Accessibility Assessment Report

Proposed Multi Level Warehouse Facility
49 Stephen Rd. Banksmeadow, NSW 2019

30 October, 2024

Reference: 230396

1 GROUND M - AREA 1 : 500

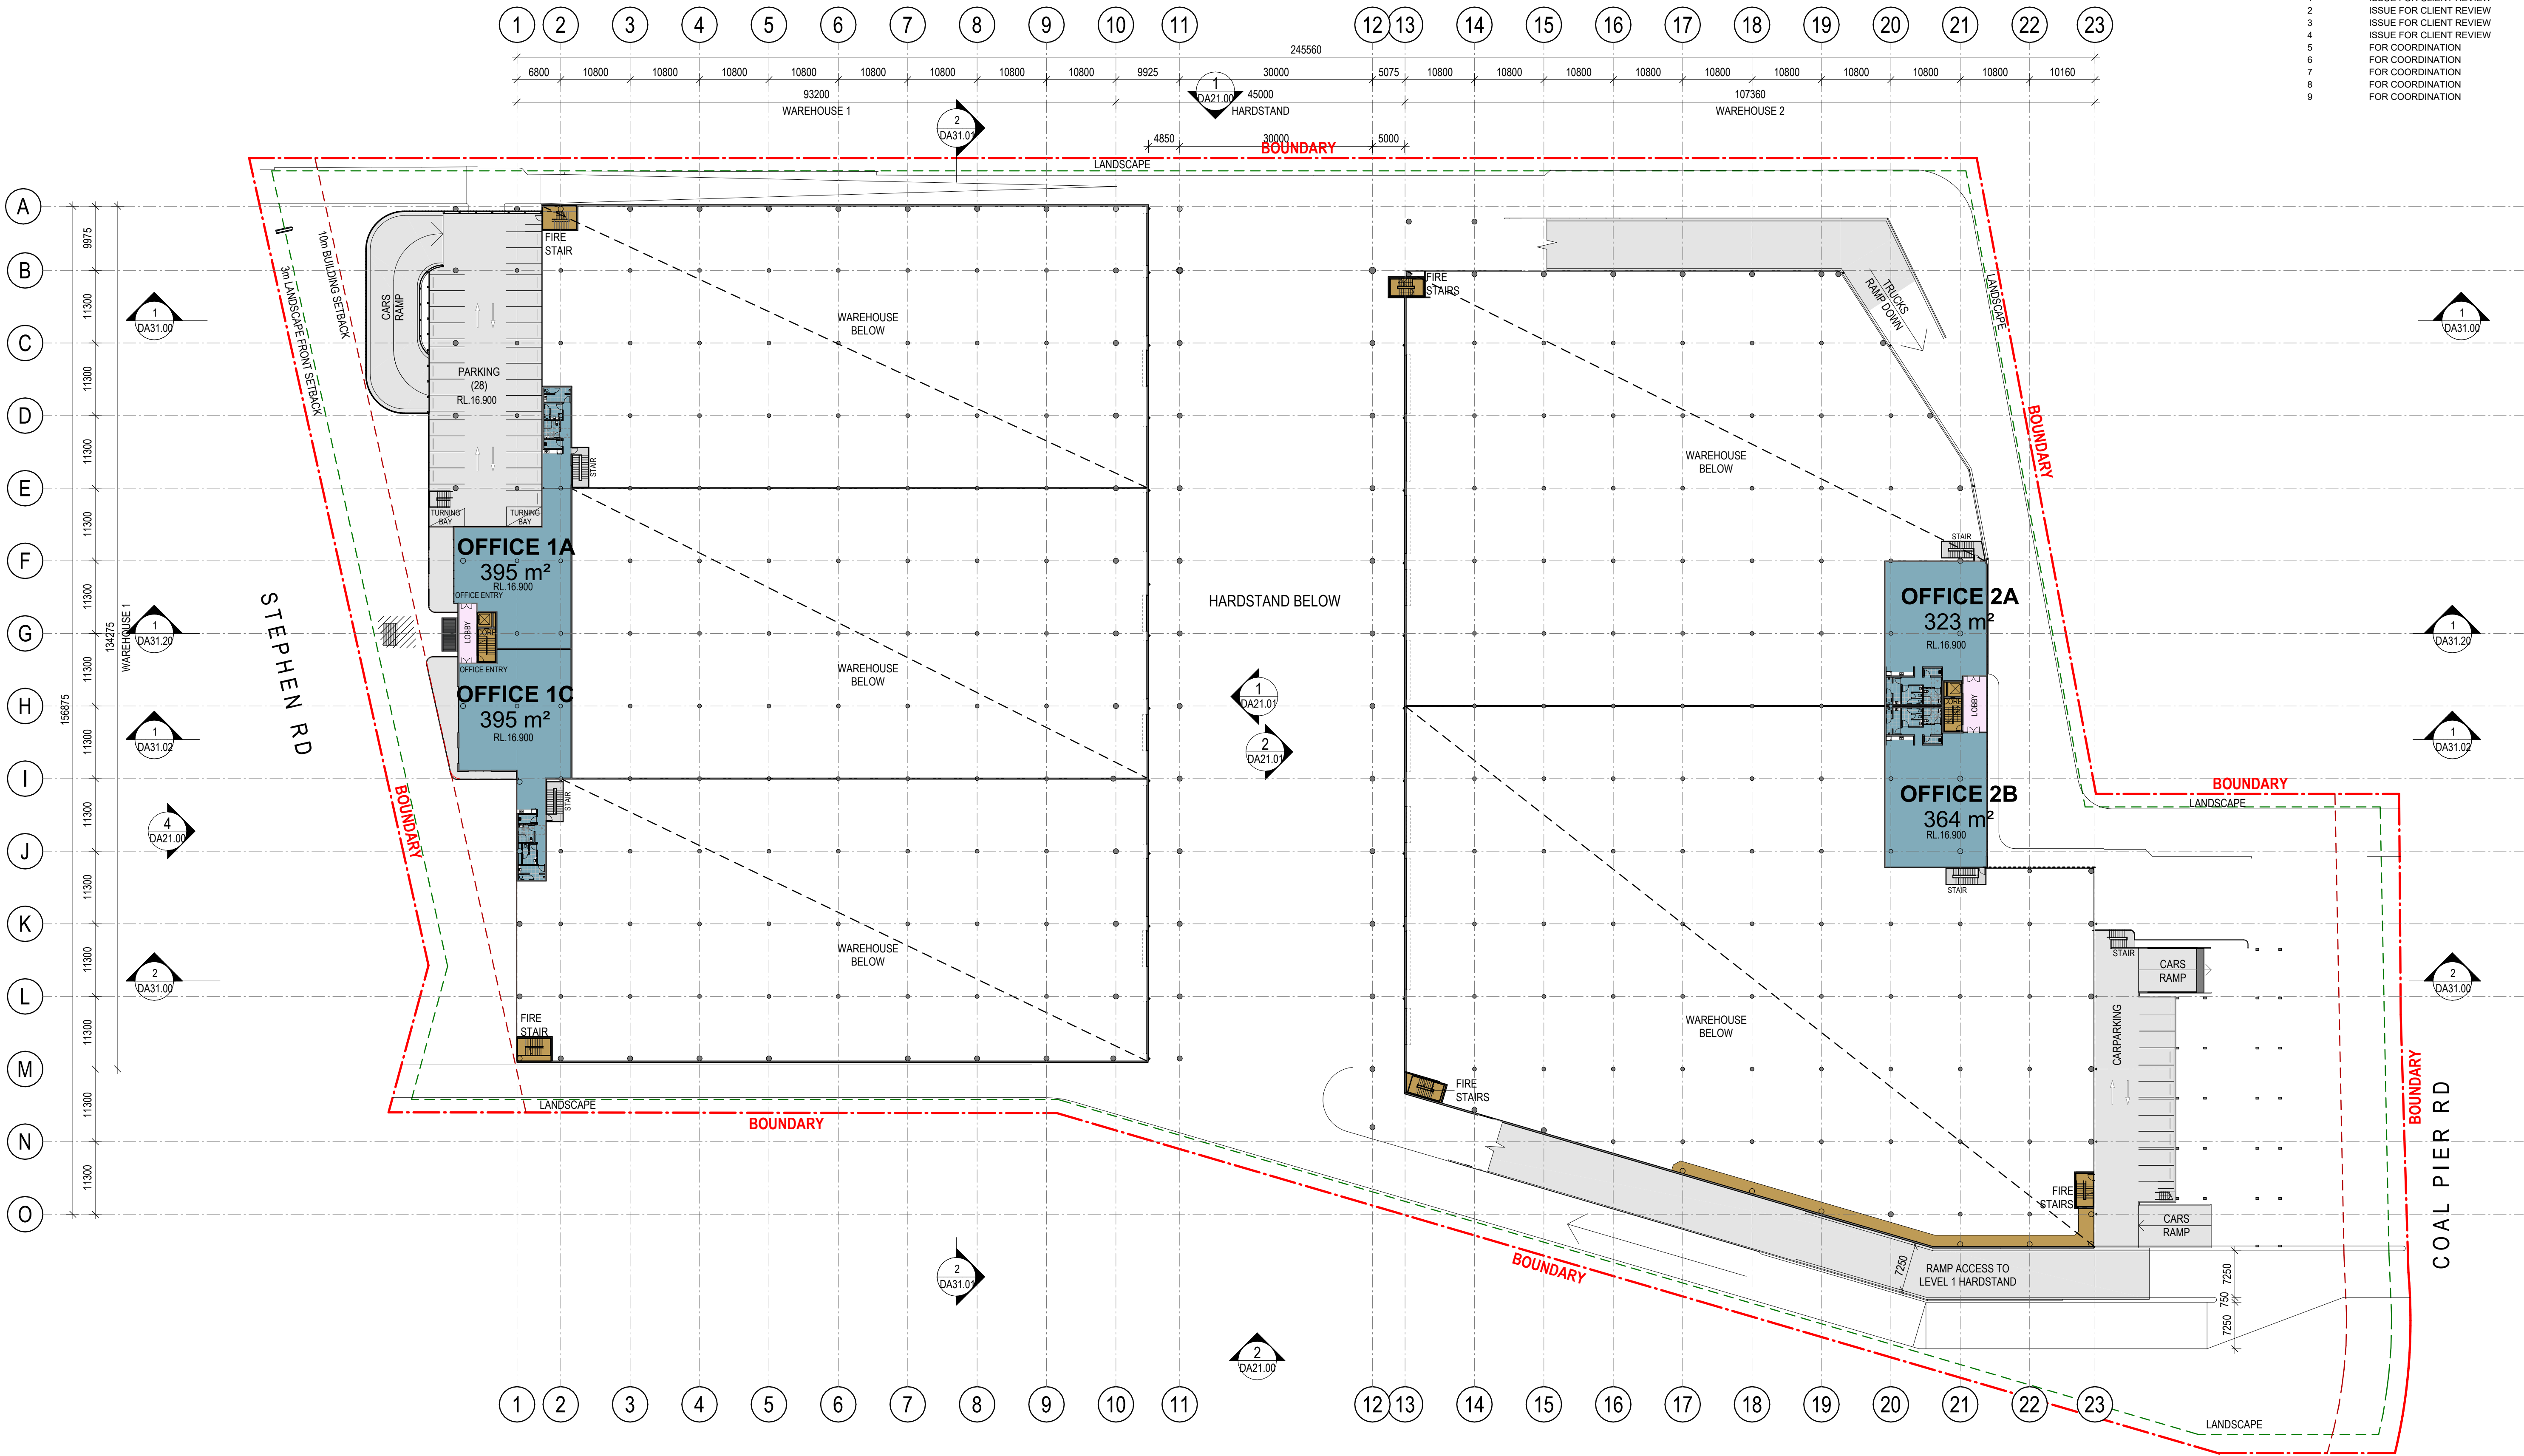
+ BCA (DtS) Clause	+ Description
1. D4D4 AS 1428.4.1 CL.2.5	ESR to confirm if the Ground Floor Mezzanine carpark has the pedestrian area at the same grade as the carriageway.

2. D4D4 AS1428.1 CL. 6.1, CL 6.3	There are instances of obstructions throughout the accessible path where the pathway is reduced to less than 1m wide.
3. D4D4 AS1428.1 CL. 6.4, CL 6.5	There is no provision for passing/turning space on the Ground Floor Mezzanine.
